17 January 2022

**Application for non-material amendment following a grant of planning permission  
Town and Country Planning Act 1990  
10 Greycoat Place, London, SW1P 1SB**

On behalf of our client, Victoria Spaces (UK) Ltd, this application is made under the Town and Country Planning Act 1990. It seeks to make non-material amendments to the planning permission for the proposed redevelopment of 10 Greycoat Place, SW1P 1SB (hereafter known as 'the site') (Planning Application Ref: 20/05884/FULL).

Drawing Title  
S96a Planning - Proposed East Elevation

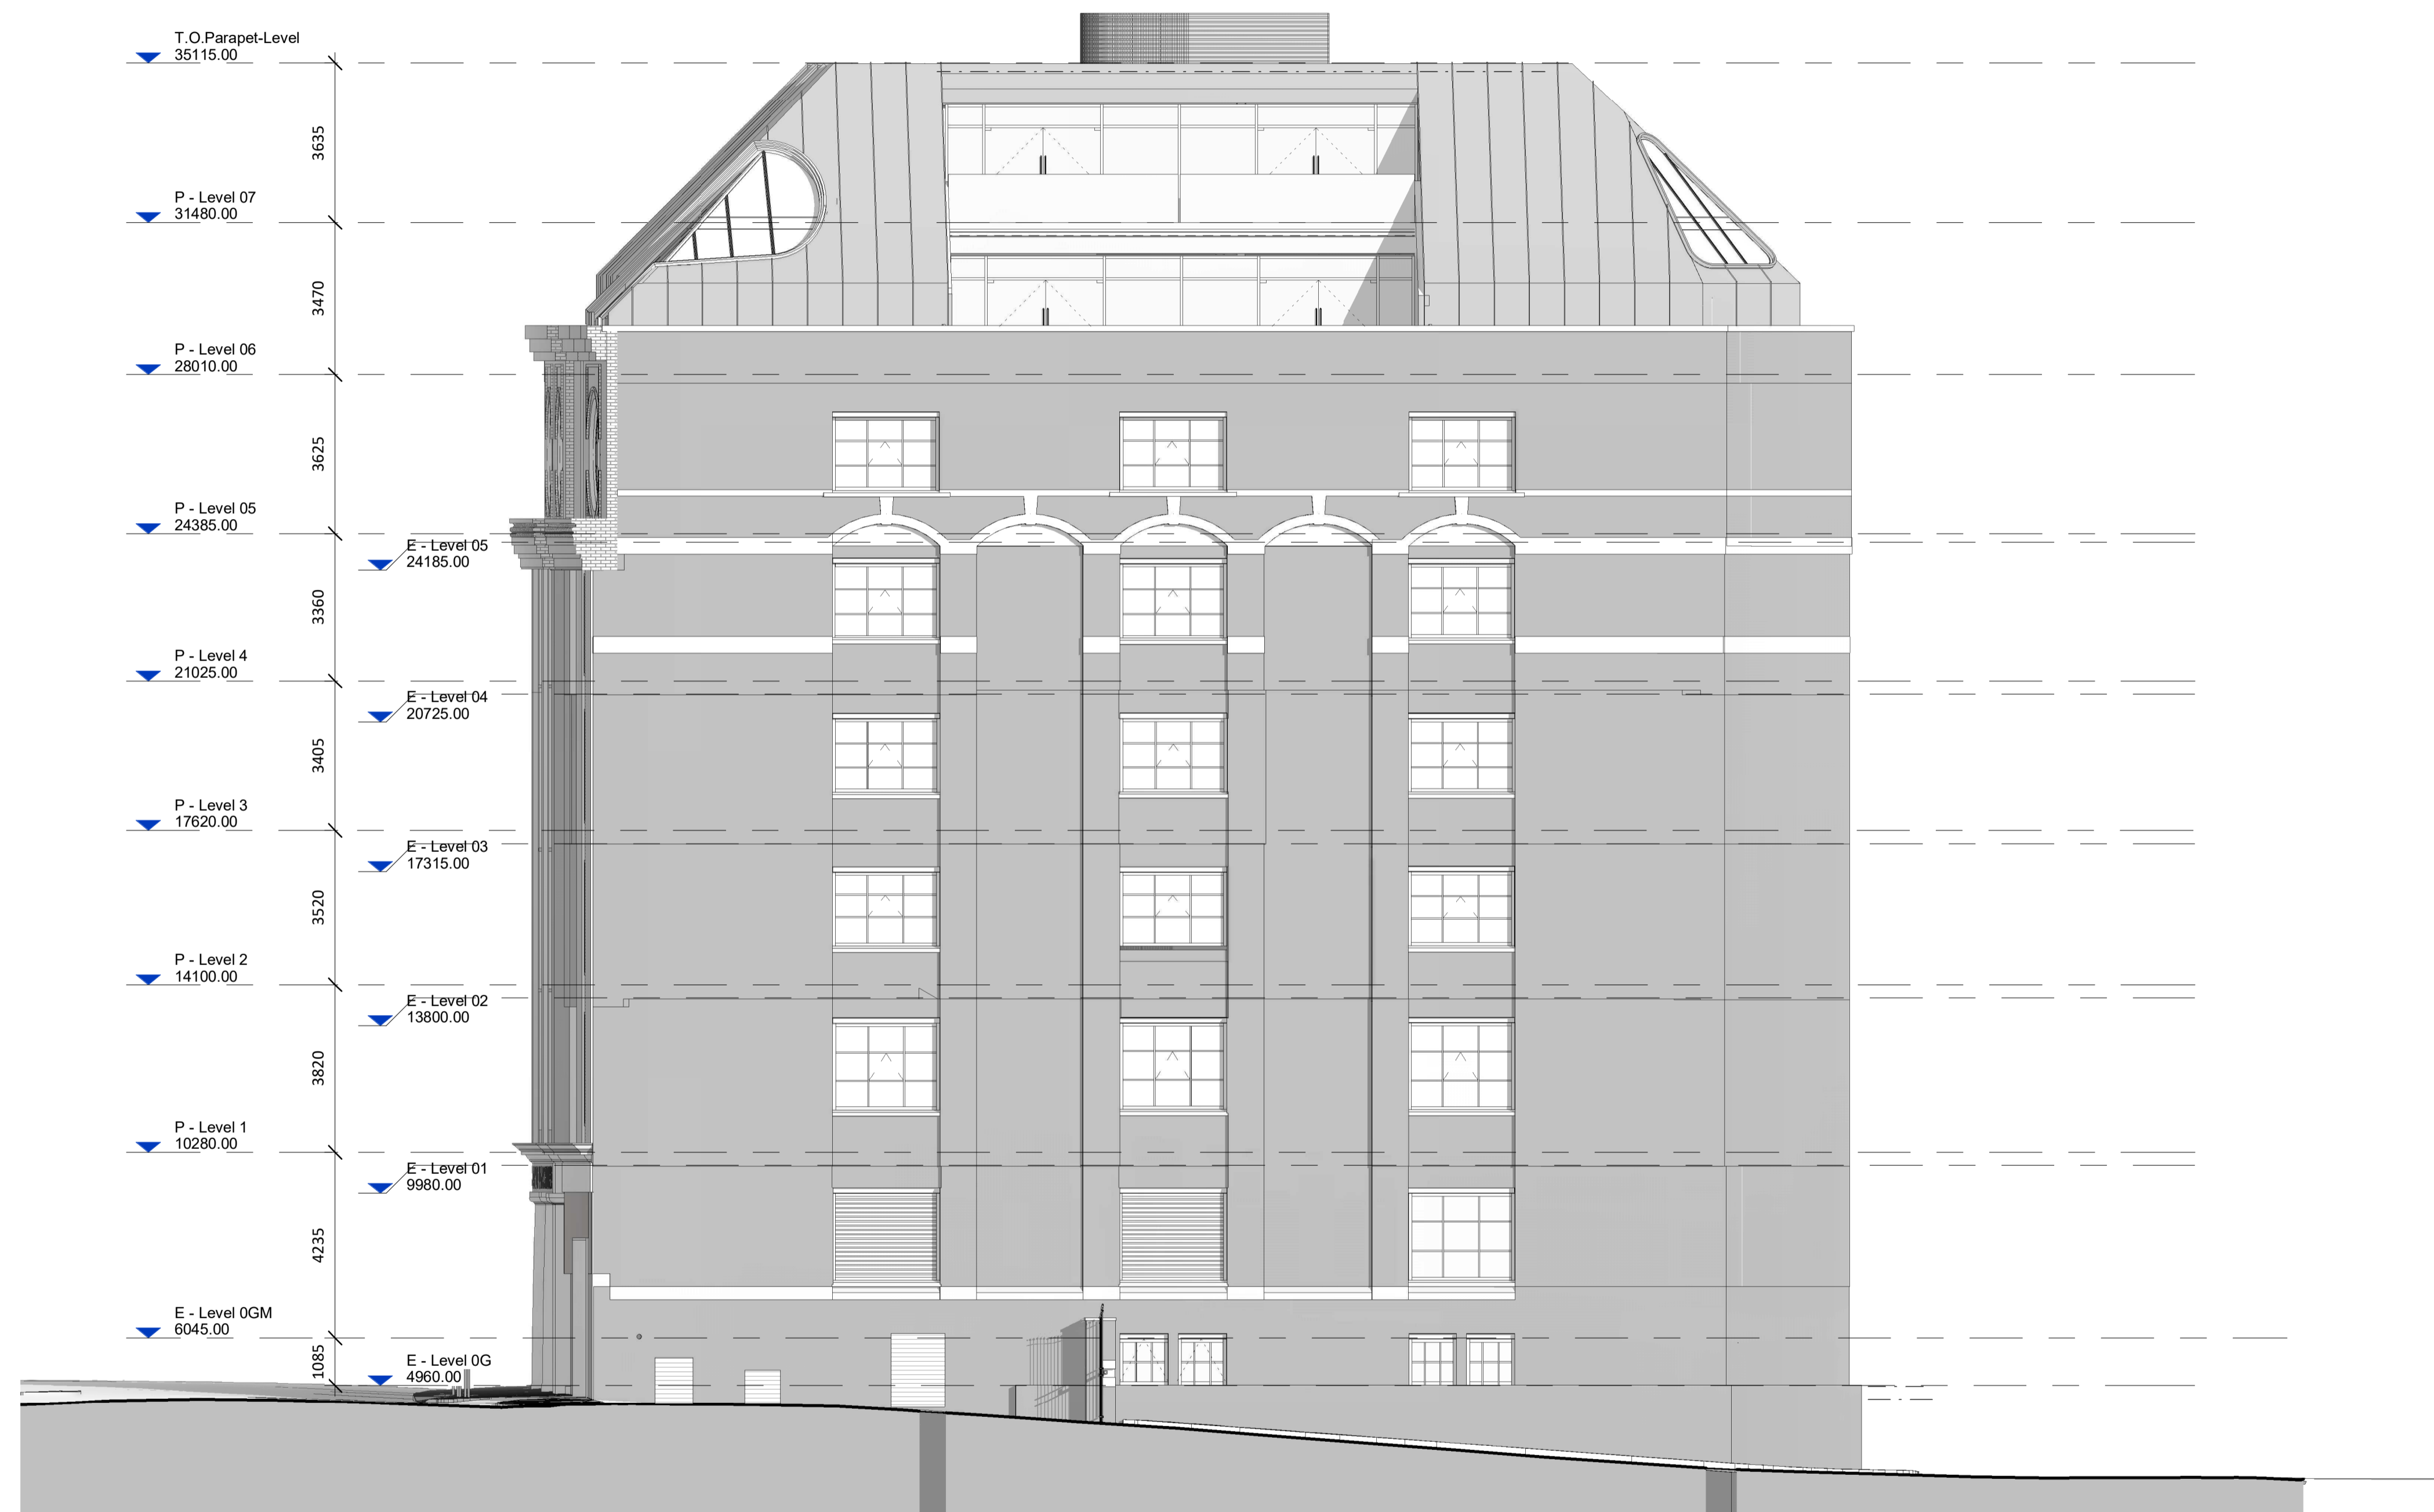
## Sixth Floor – East Facing Terrace

The proposals include the reduction in the East facing external terrace so that 19 sqm of consented external terrace space will become internal office space as shown on page 6 of the submitted Design and Access Statement.
